Development Control
Ribbles Valley Borough Council

Your ref: 24.0990
Our ref: D3.24.0990
Date: 17th March 2025

Address: Barrowbridge House Club Street Barrow BB7 9AY

Proposal: Technical details following permission in principle application (3/2023/0989) for residential development comprising 4 dwellings.

Client Mr S Gill		
Project Proposed Development at Barrow Bridge House Club Street Barrow Clitheroe BB7 9AY		
Drawing Title Plots 3 and 4 Garage Plan and Elevations		
Scale 1:50/100 @ A2	Date Nov 2024	Drawn LFR
READ DESIGN LTD		
161 - 07

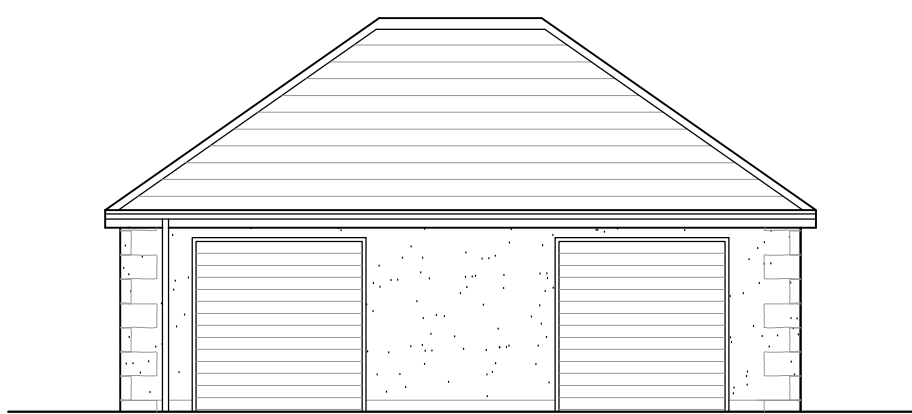
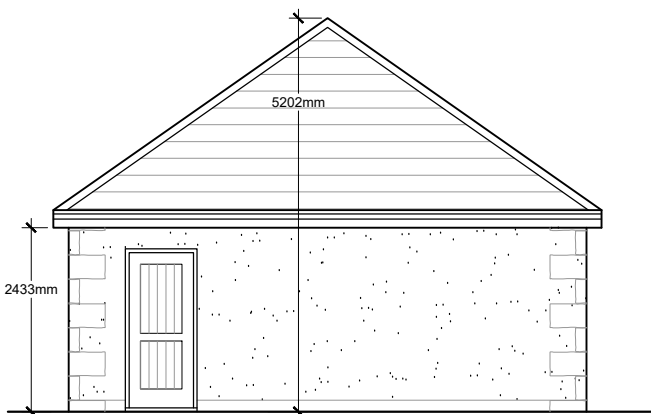
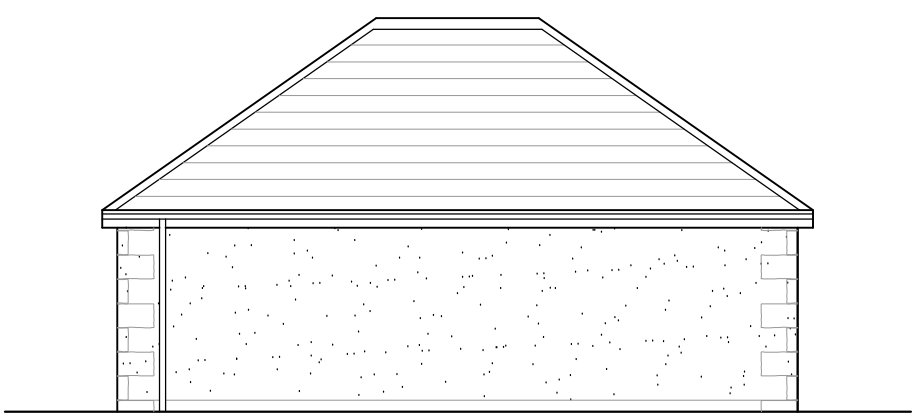
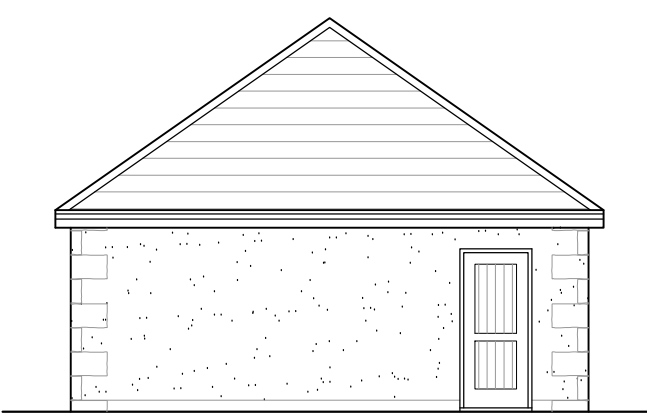
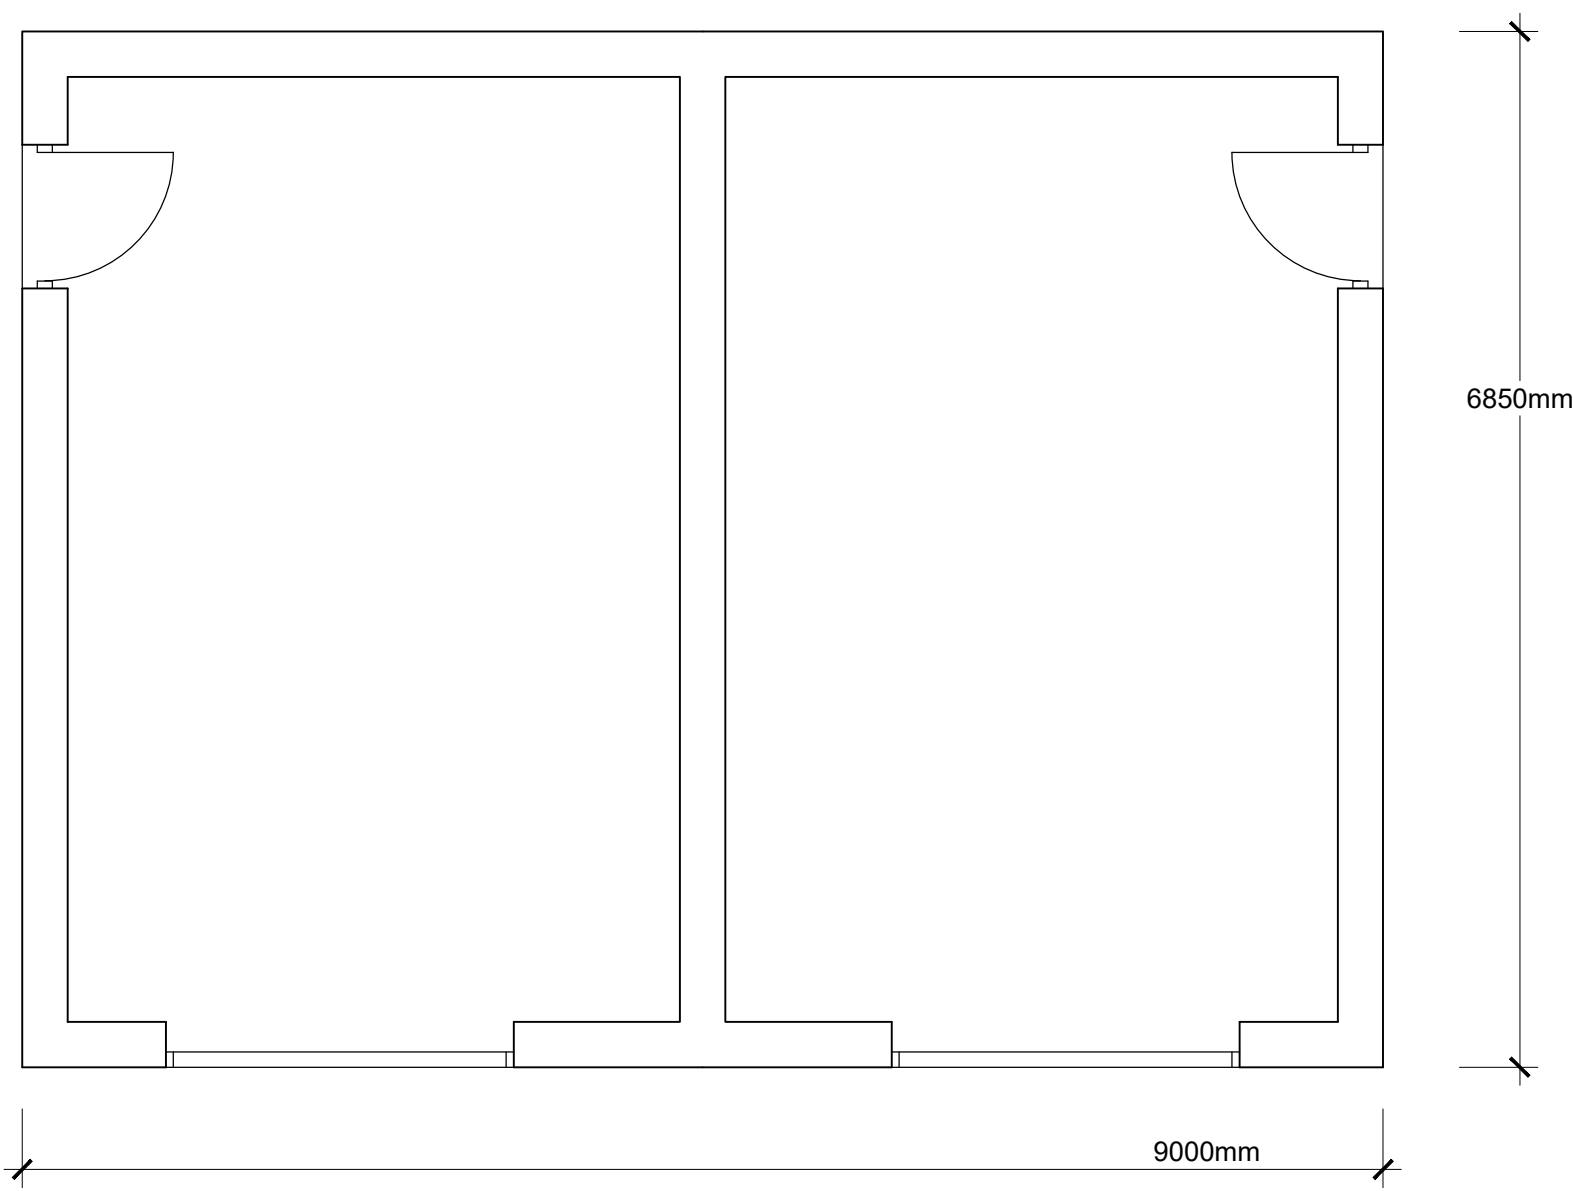
Plots 3 and 4 have detached single garages measuring 4m by 6m internally which is sufficient to count as a car parking space and secure cycle parking (3m by 6m). The distance between the garages and the access road has been extended to 5.2m long with a roller shutter door is fitted to the garage, rather than up and over. This is considered acceptable.

7.5T Box Van (8m Long)

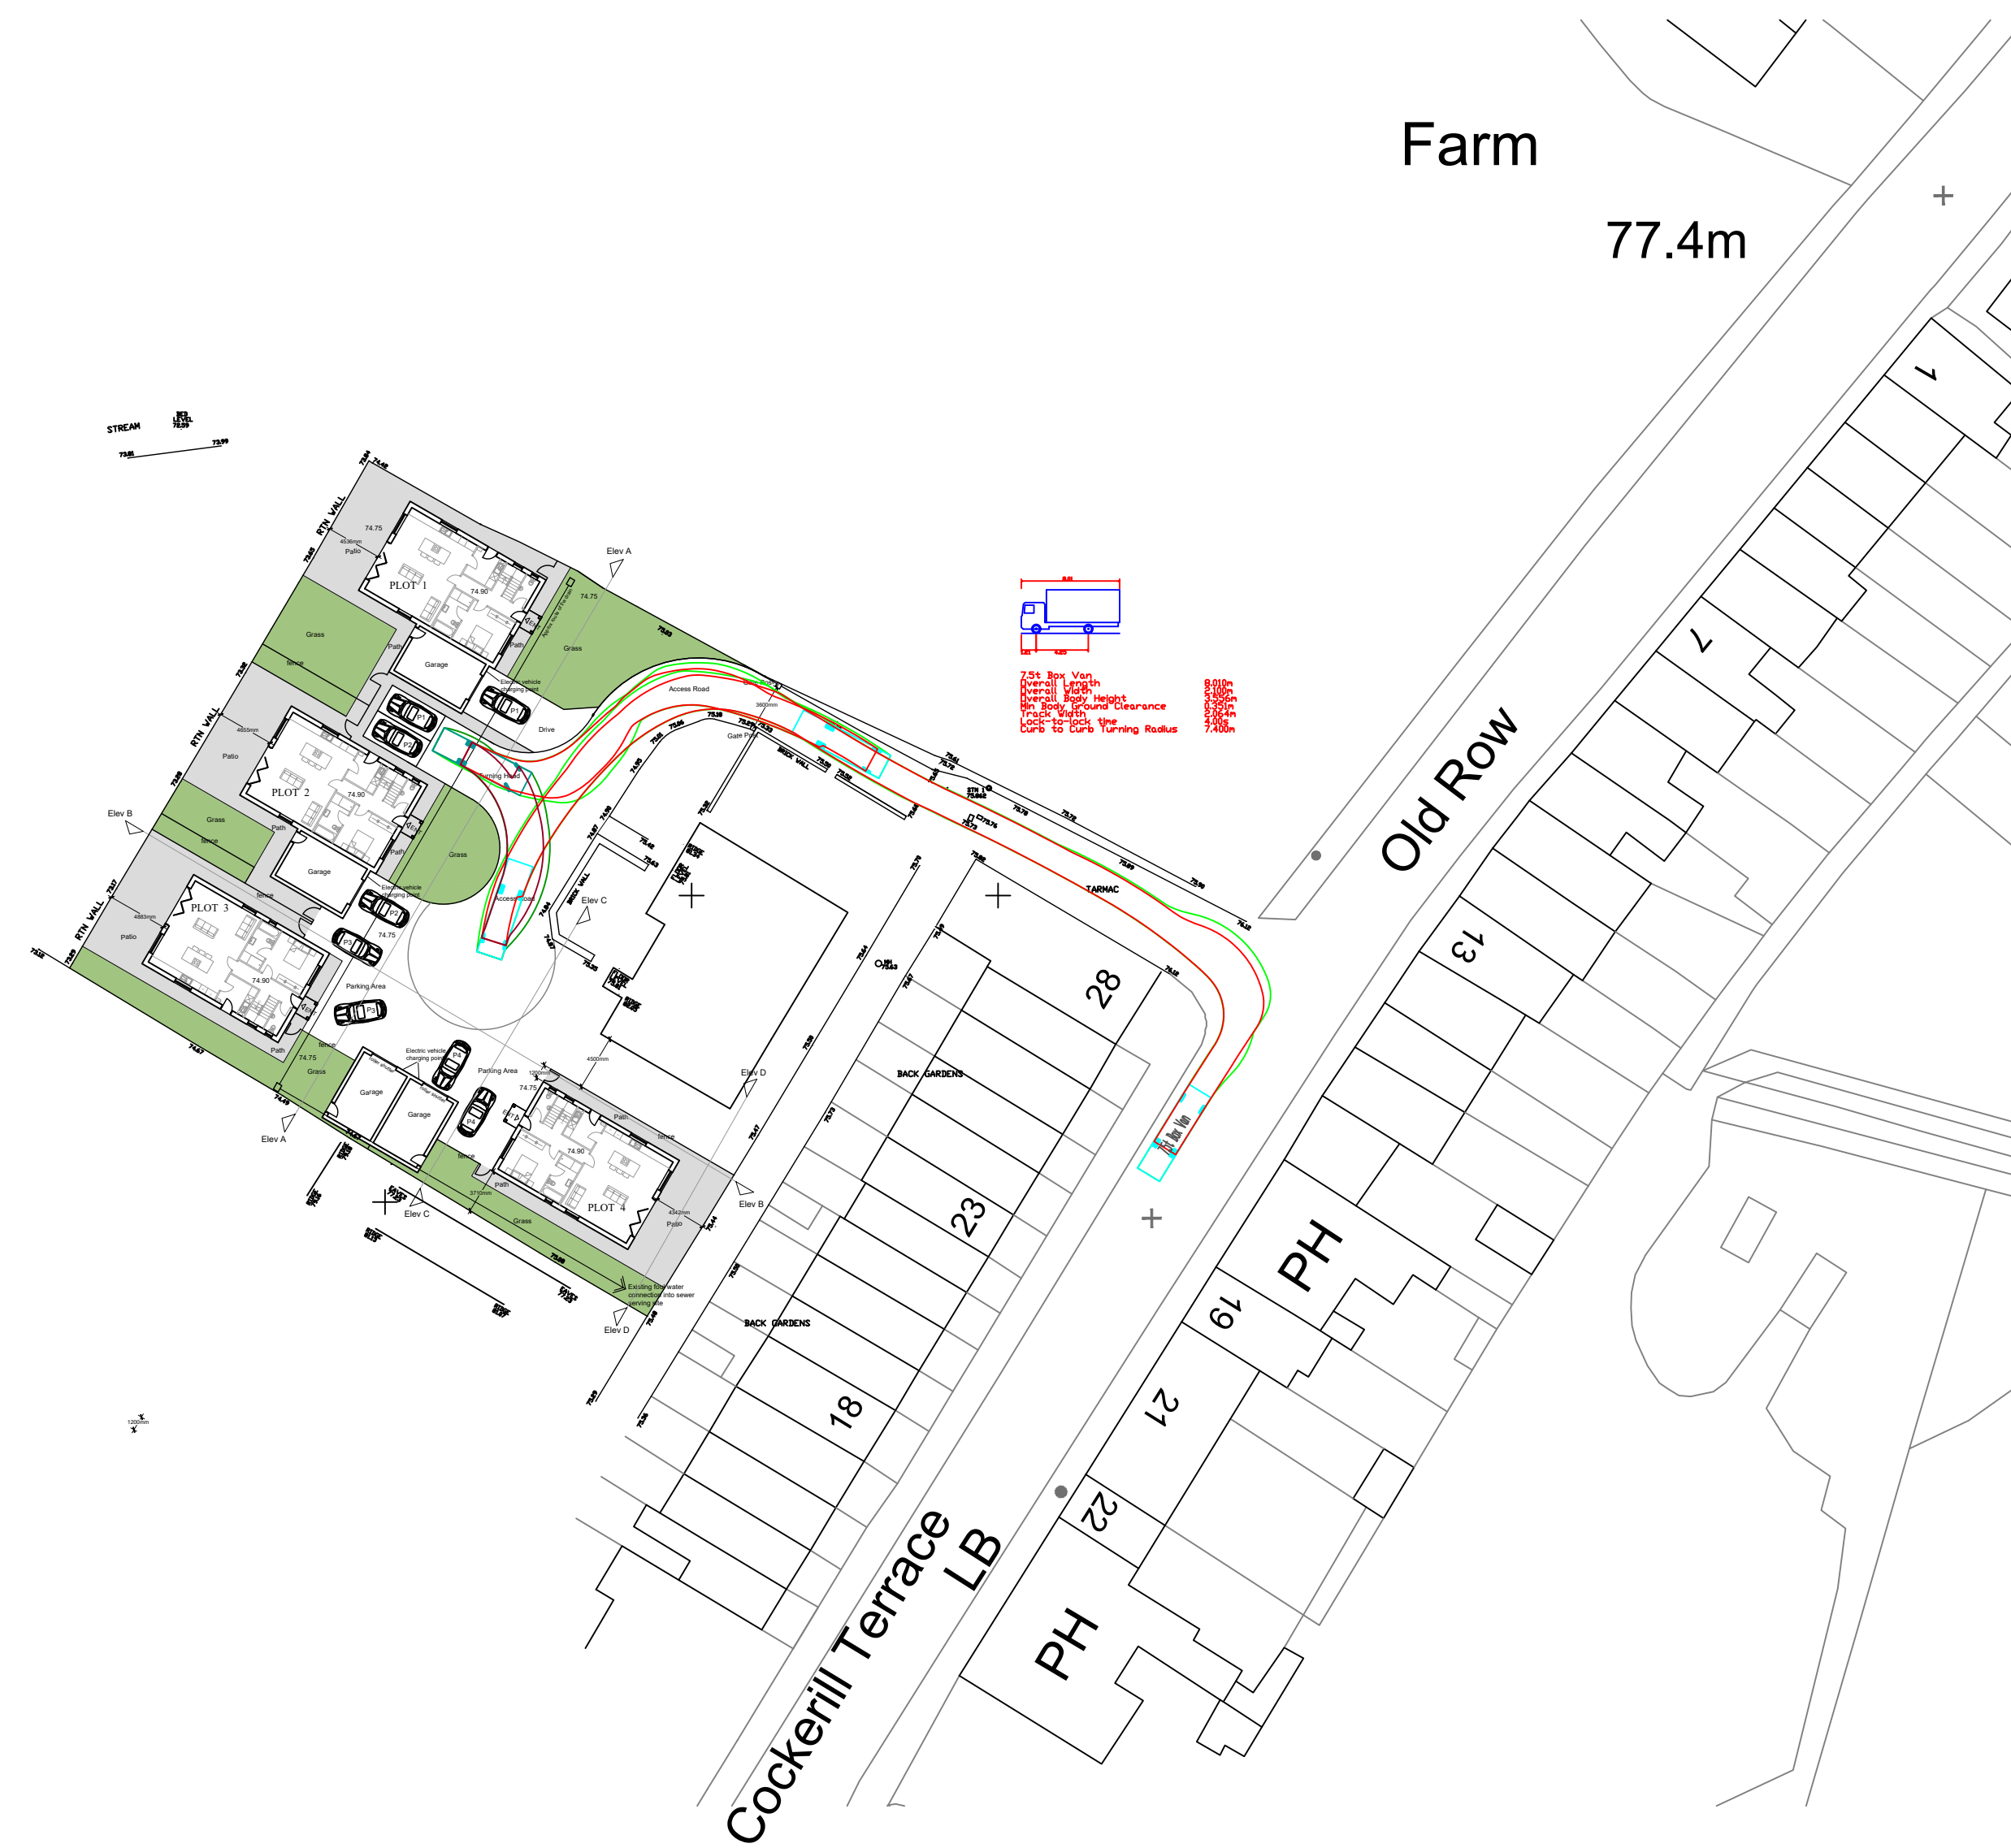
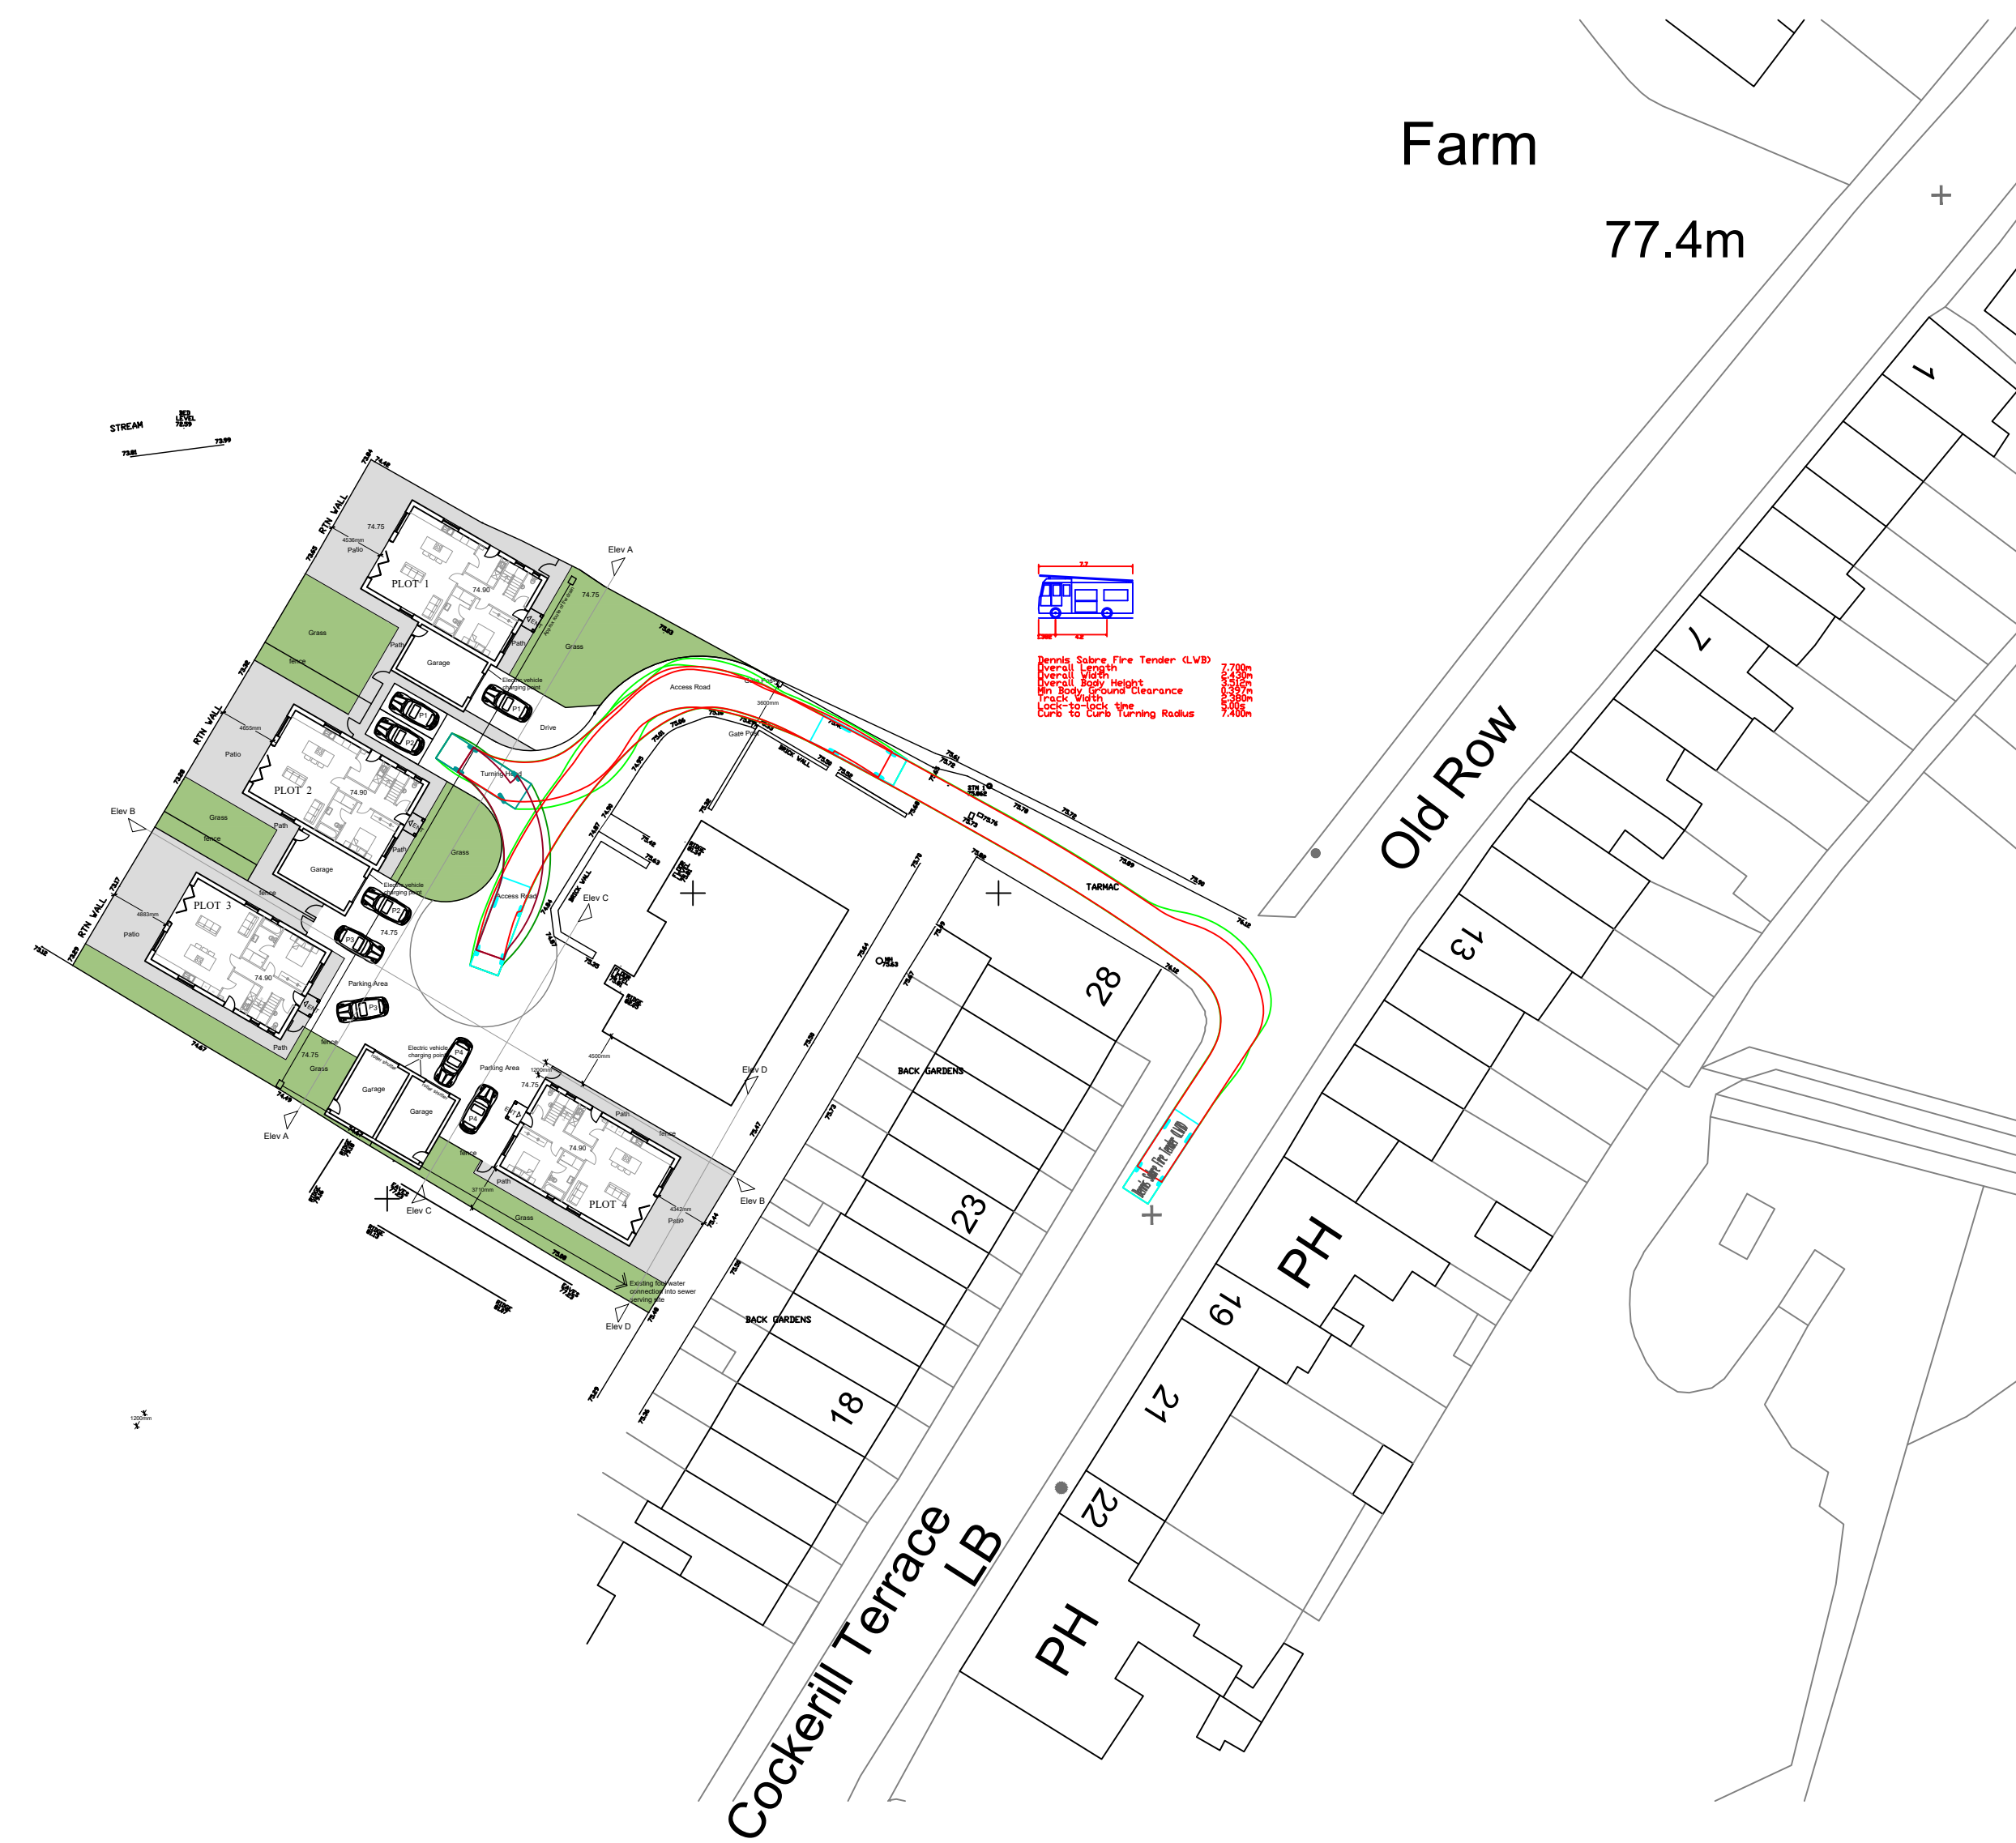
A swept path analysis for a 8m long box van and a 7.7m long fire tender is submitted to demonstrate that the vehicle can enter and exit Whalley Road in forward gear.
